29 November 2012

North West Rail Link Environmental Impact Statement Stage 2 – Stations, Rail Infrastructure and Systems

**BLACKTOWN CITY COUNCIL SUBMISSION
NORTH WEST RAIL LINK
ENVIRONMENTAL IMPACT STATEMENT – STAGE 2**

Figure 6.43 Indicative plan of Tallawong Stabling Facility at Day 1 of operations

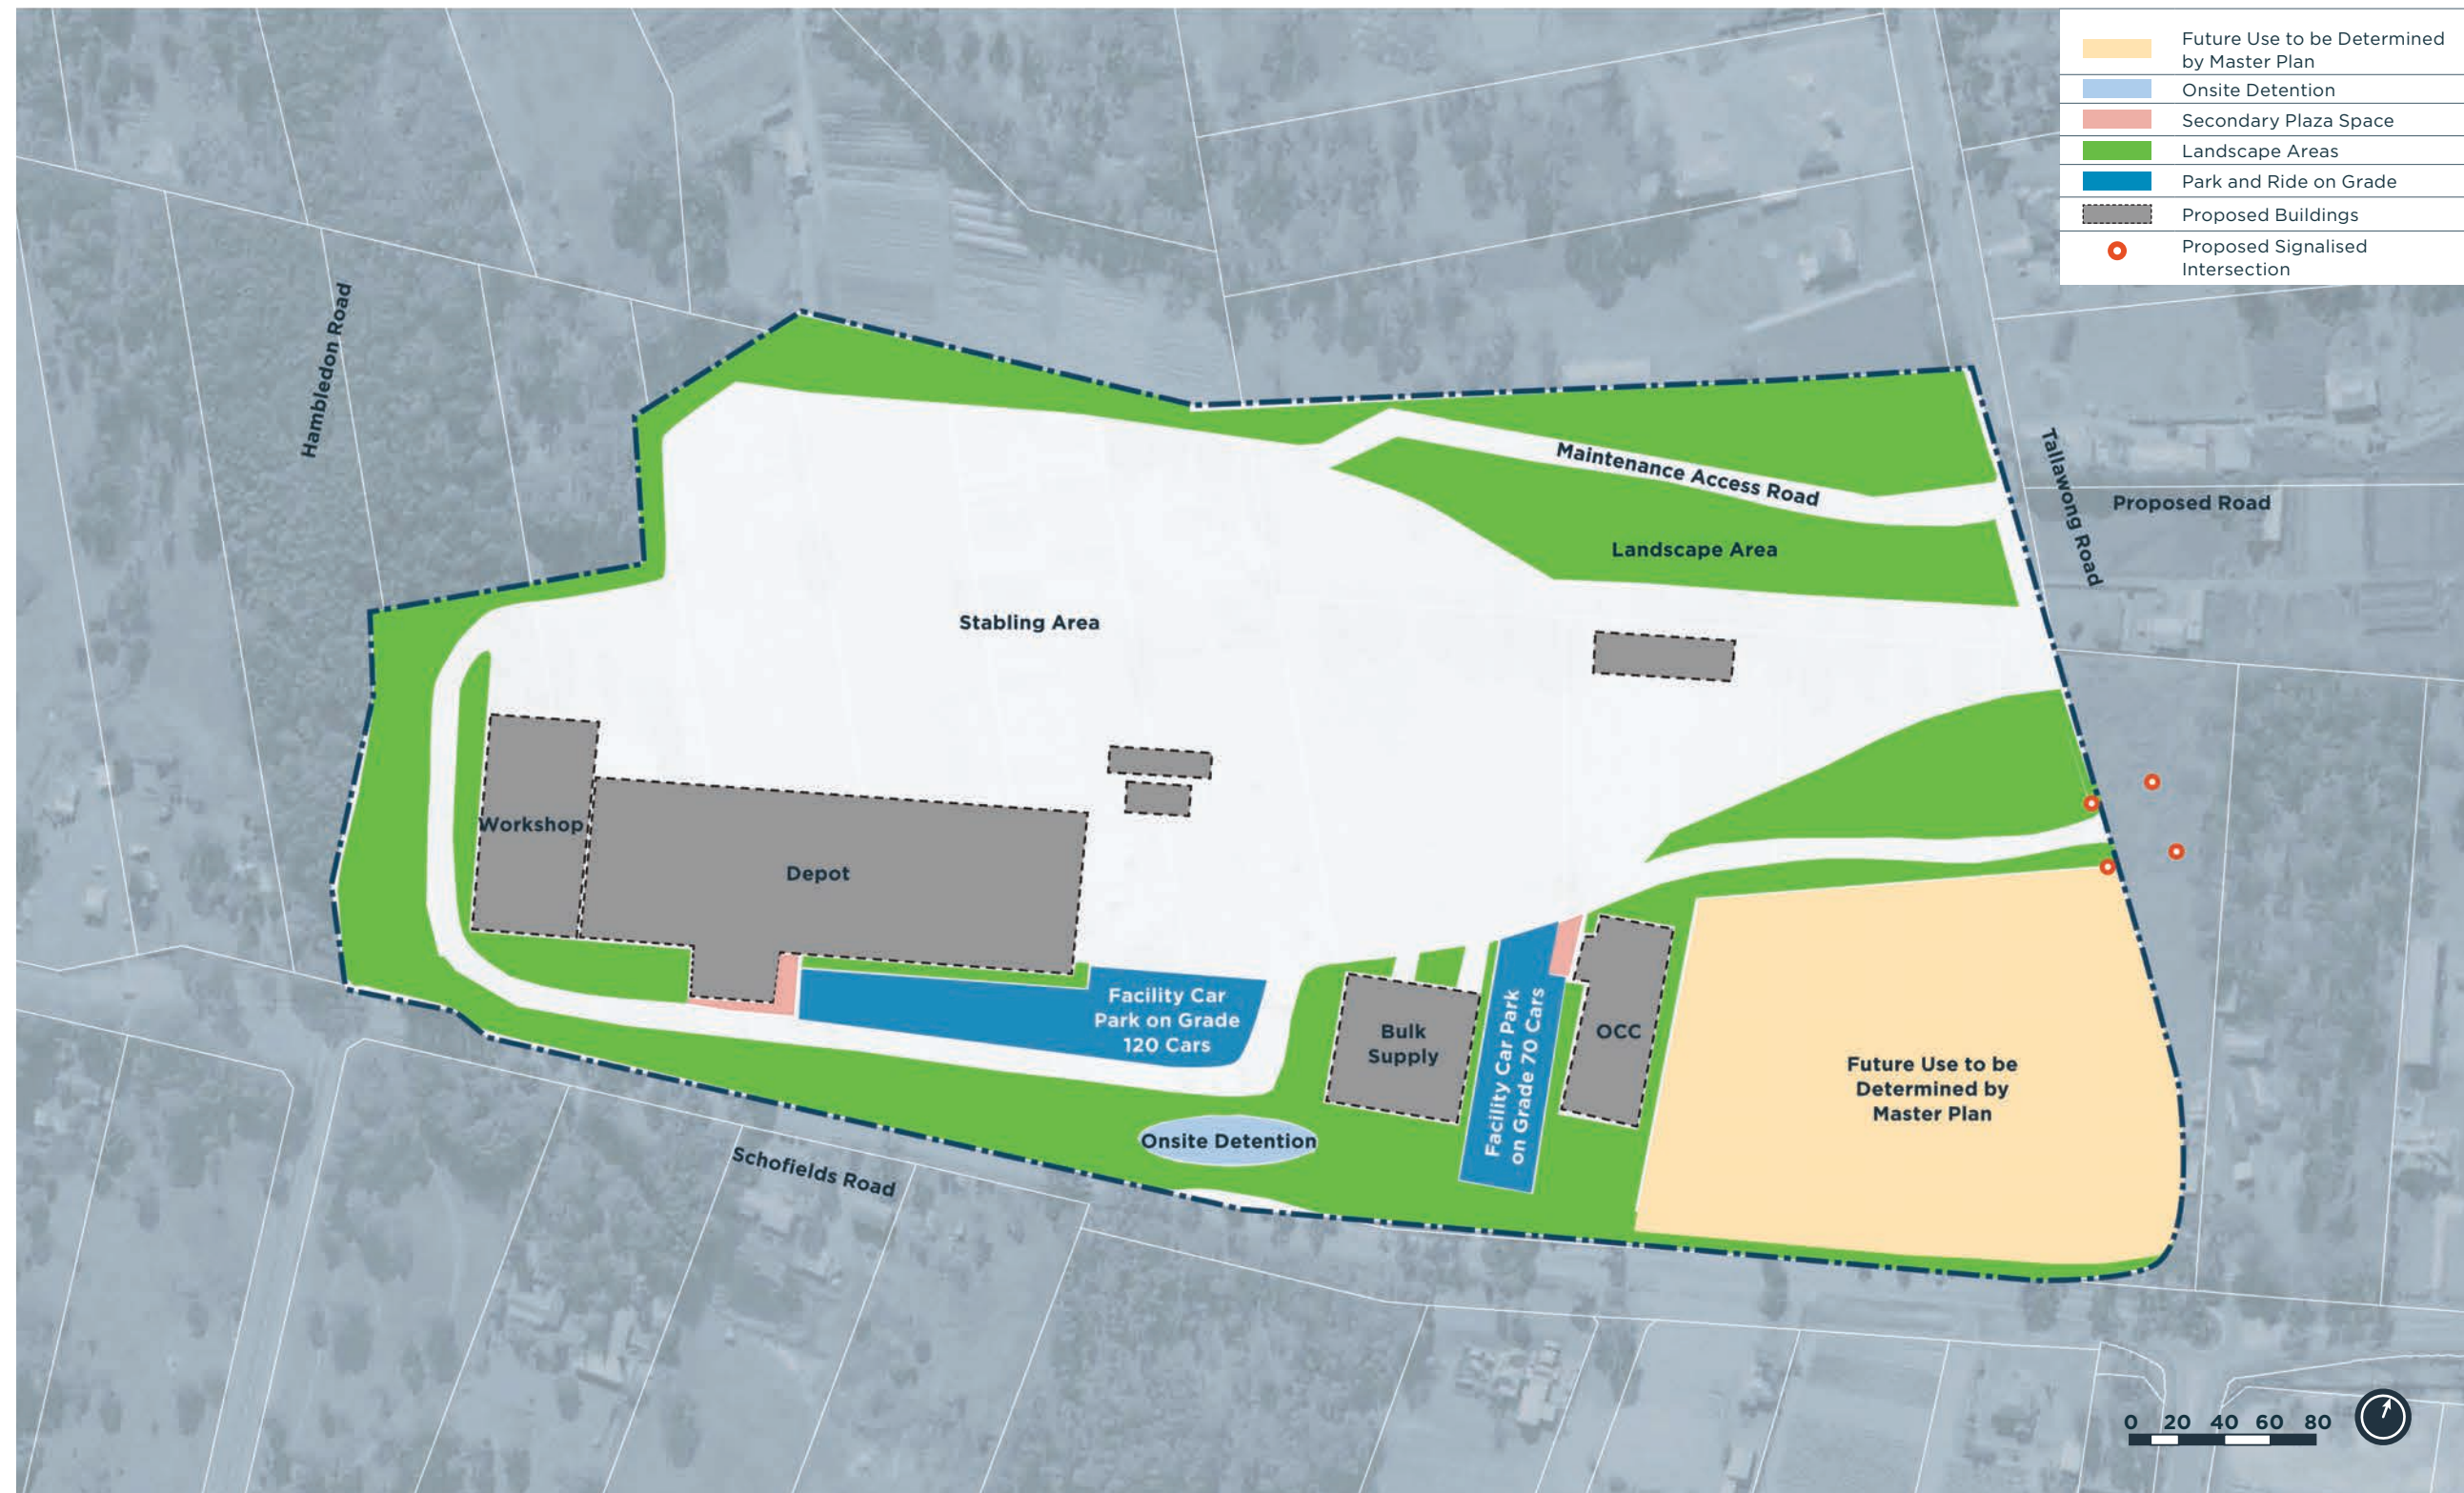
- b) The location of the Tallawong Road Stabling Yard will need to be coordinated with the proposed Schofields Road extension and upgrade, particularly at the Schofields Road – Hambledon Road intersection. Stormwater detention is to service the entire site to attenuate post-development flows to no higher than pre-development flows for the full range of ARI from 1 in 1-year to 1 in 100-year (Figure 6.43).
